FOUNDATION LUTHERAN CHURCH

TOWNERS AVENUE, FALCON, COLORADO

Add "PCD File No. PPR2321"

DEVELOPMENT PLAN COVER SHEET

L1

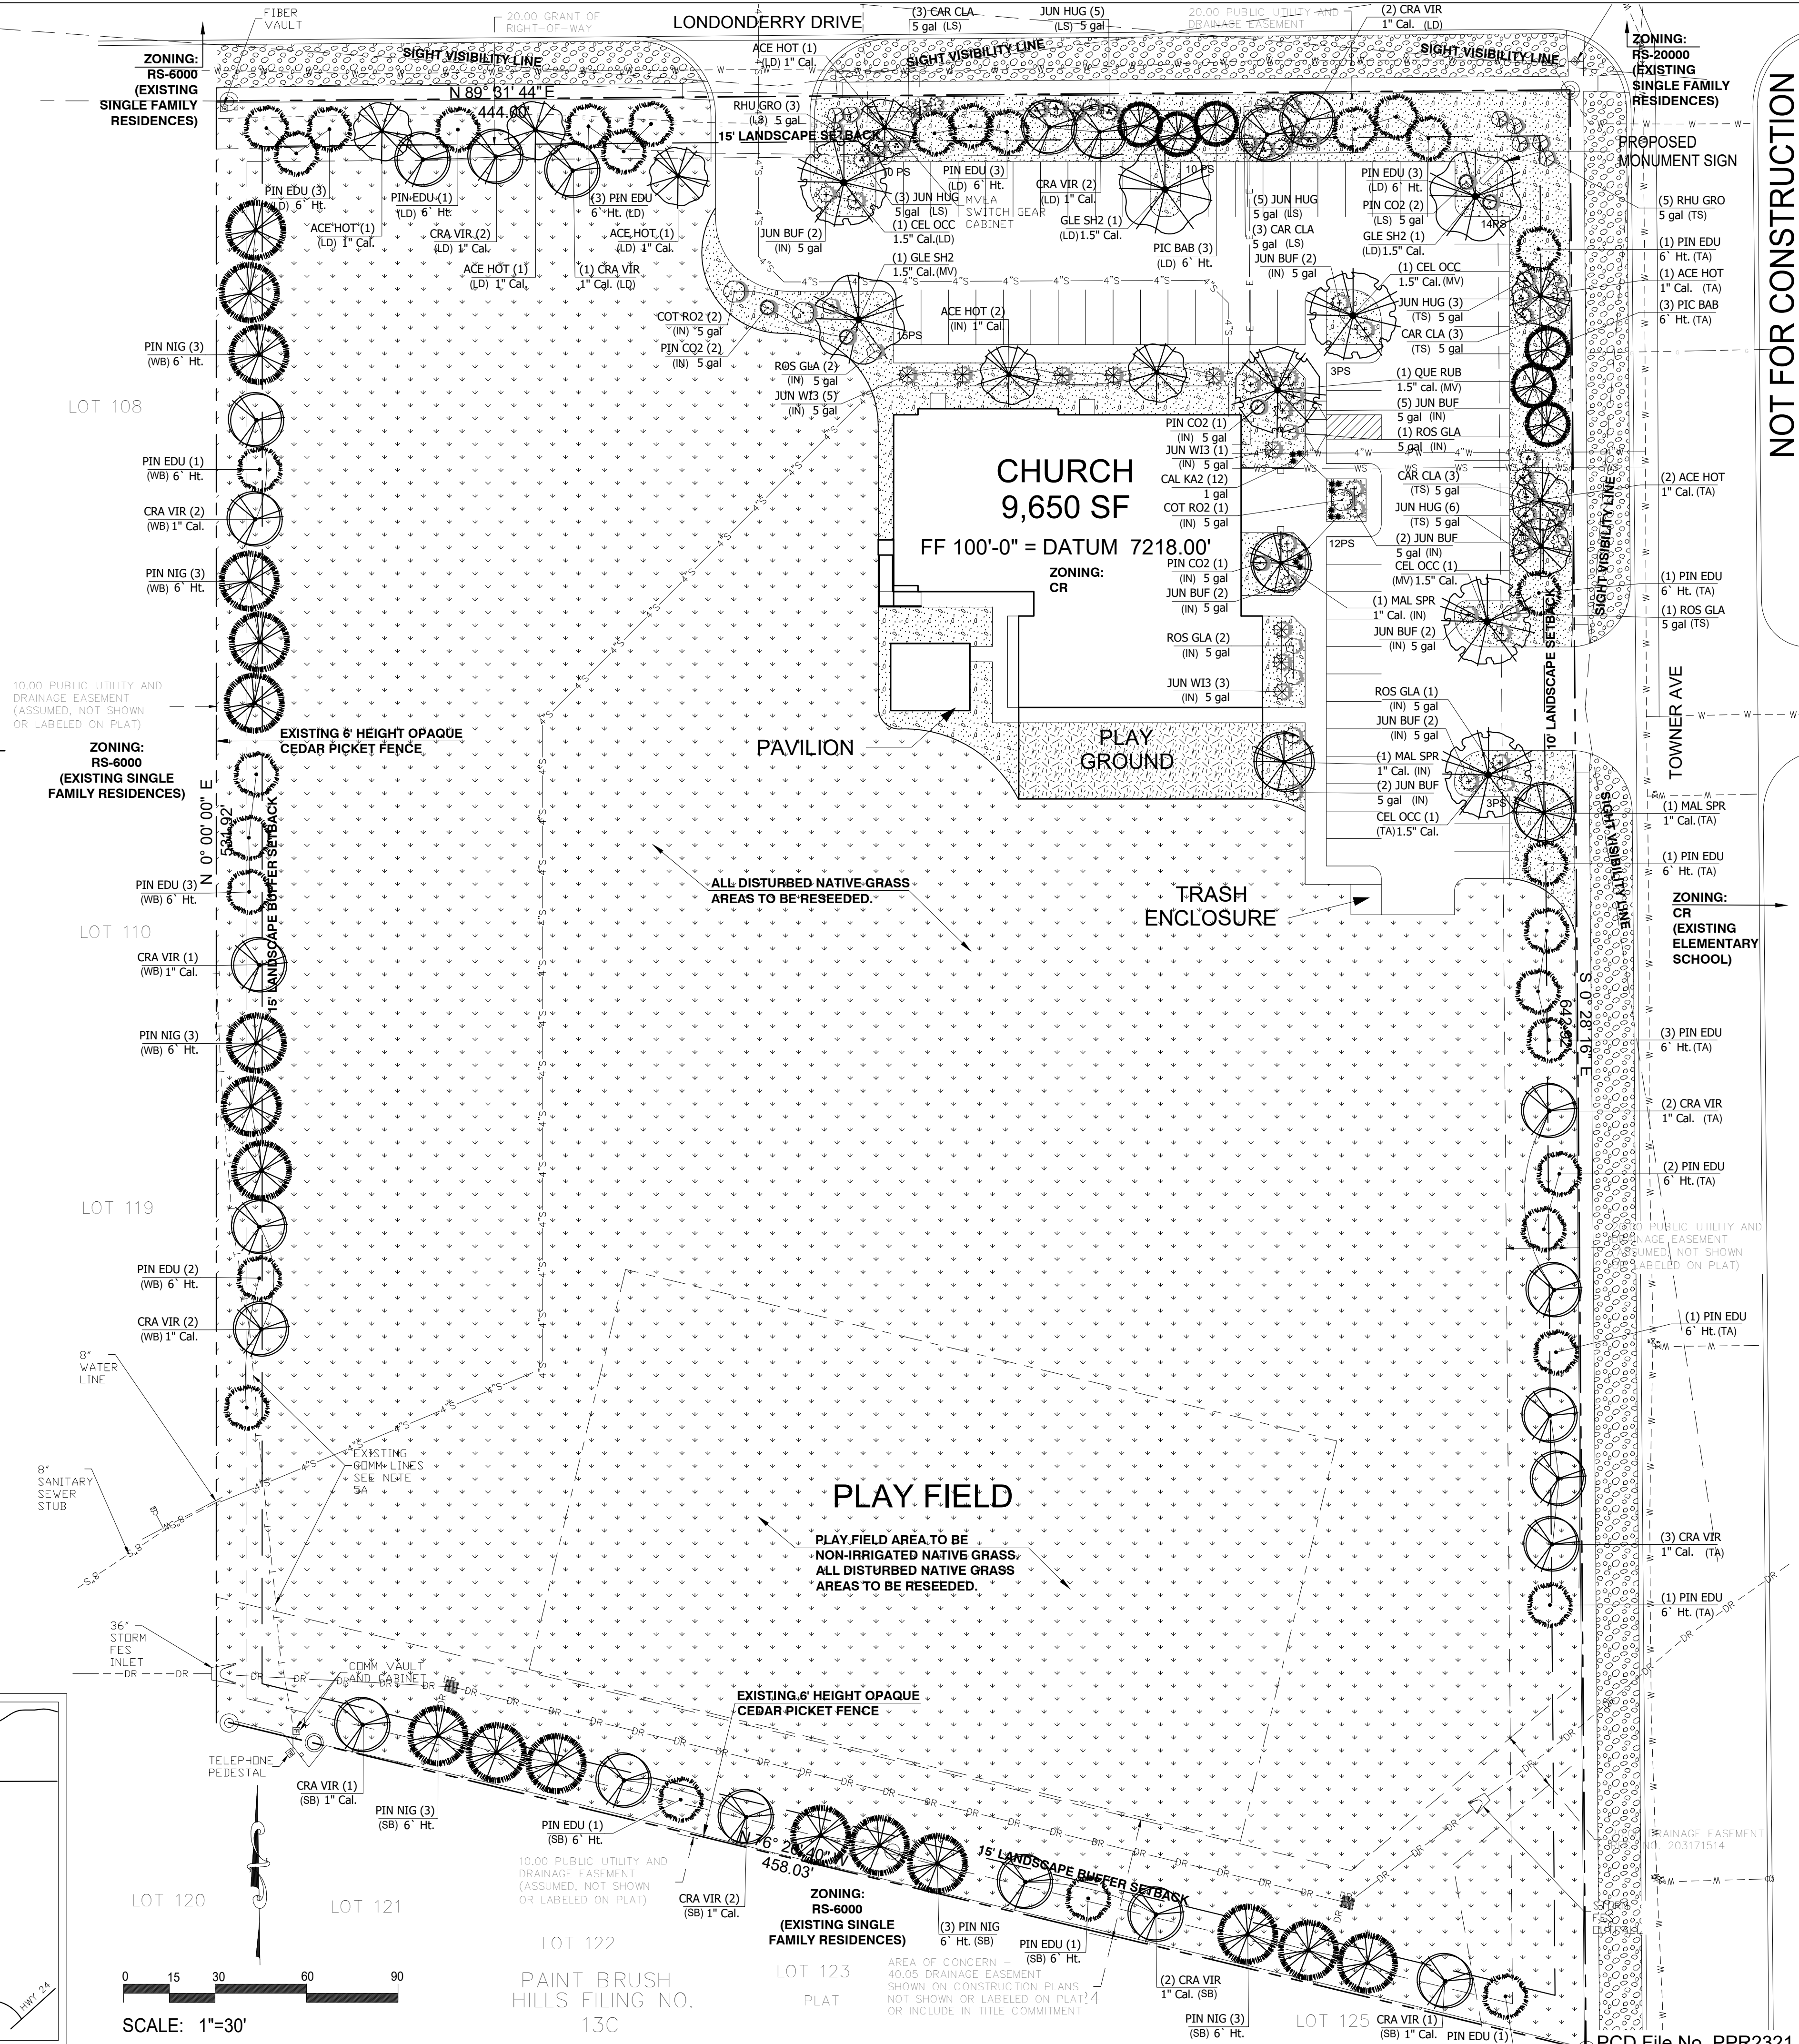
Unless otherwise approved by the ECM Administrator, the depth of roadway landscaping shall be measured from the property line. Where a roadway easement has been provided, the measurement shall be from the ROW or roadway easement. In reference to the landscaping Located on Londonderry Drive and Towner Ave

Identify all Location and dimension of the all property lines, rights-of-way, and all existing and proposed easements.

You will need to provide the required Buffer and Screen area around the Western and Southern Boundary.

Area Calculation. The entire lot, parcel or tract area shall be used as the basis for calculating required the internal landscape area. In instances where an entire lot, parcel, or tract is not used for the proposed development, the area used to calculate the required internal landscape area may be reduced by the PCD Director based on the area of the lot, parcel or tract actually being developed or used. The minimum landscaping requirements may apply to just that project area determined by the PCD Director to be developed or used. However, even if reductions in the lot area are approved, the PCD Director may require that additional landscaping (including buffering or screening) is provided at the first stage of a larger project to mitigate environmental impacts or meet the intent of the landscaping provisions of the LDC.

D)Required Buffer and Screen Areas. Buffer Between Non-Residential, Multifamily Residential and Single-Family/Duplex Uses. (a)Where Required. A buffer is required in the following situations:(i)Along the lot, parcel, or tract line on the non-residential use property between the non-residential use and a residential zoning district.(ii)Along the lot, parcel, or tract line on the multifamily use property between the multifamily use and a single-family or duplex zoning district.(iii)On the residential side of the project when use to use compatibility is a concern.(b)Depth and Planting Standards. The required buffer shall be a minimum of 15 feet deep. The minimum number of trees in the buffer shall be 1 tree for every 25 feet of common lot, parcel, or tract line. A minimum of 1/2 of the trees shall be evergreen trees.(c)Opaque Fencing or Wall Required. An opaque fence or wall with a minimum height of 6 feet is required along the lot, parcel, or tract line except where the adjacent single-family or duplex residential zoning district or use abuts a required roadway landscaping area.(d)Minimum Ground Covering Required. Bark, wood chips, rock, stone, or other natural landscape material shall be used as a non-living ground cover. Areas of a required buffer not covered in approved non-living ground cover material shall be covered in a living plant material.
